From: Paul Bicknell [paul@bicknells.f2s.com]
Sent: 23 February 2012 02:05
To: Planningecons
Cc: r.bower@btconnect.com
Subject: RE: Planning Consultation on: FG/16/12/
Follow Up Flag: Follow up
Flag Status: Completed

APPLICATION FG/16/12/
NO:

Registered: 06-FEB-12
Site Country Fayre Littlehampton Road Ferring BN12
Address: 6PN

Description of Works: Application for a Minor Material Amendment following a grant of planning permission FG/33/10/ for minor alterations to elevations of building, including lobby, energy centre & plant. Minor alterations to car park layout, landscaping & surface materials (this application also falls within the parish of Angmering)

Proposed Roof Plan

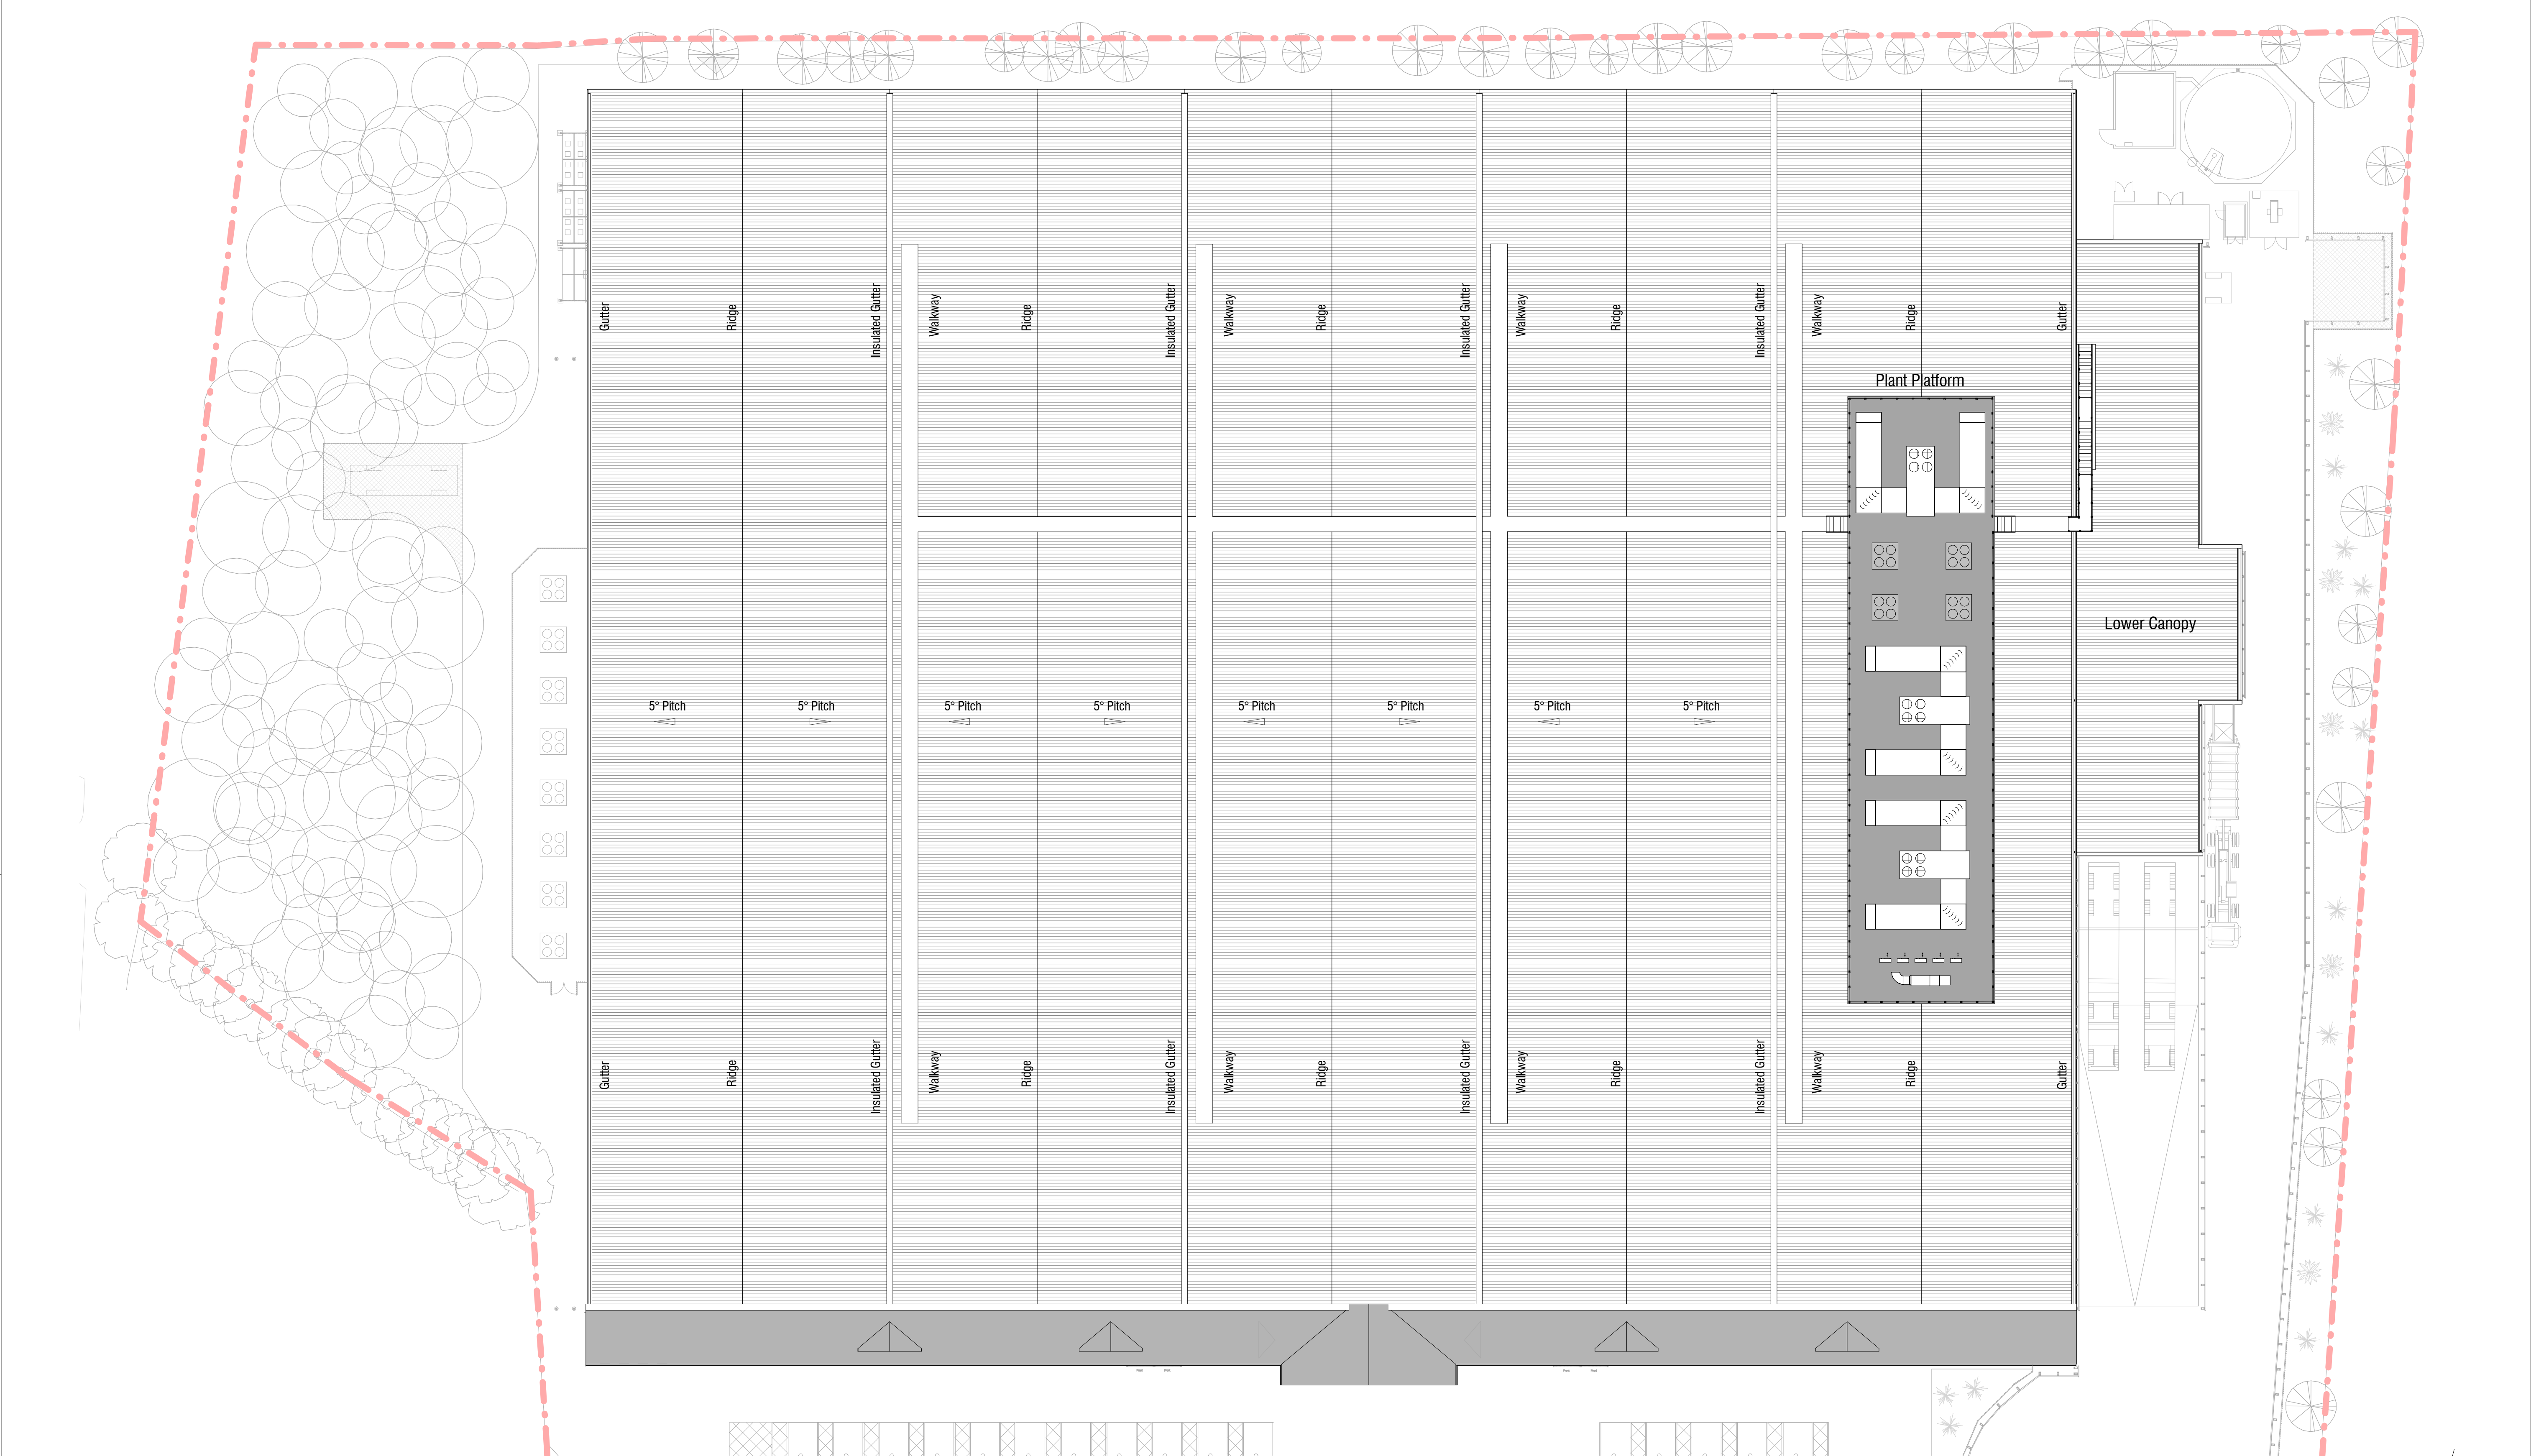
Just one item you don't mention the outside plant for the Air conditioning or is this the energy centre & plant

Is the Proposed outside Air Handling plant for the air conditioning going on the roof or on a wall thus changing the sky line .Also has the potential increase of the noise been surveyed for the hours of darkness in relation to local residence
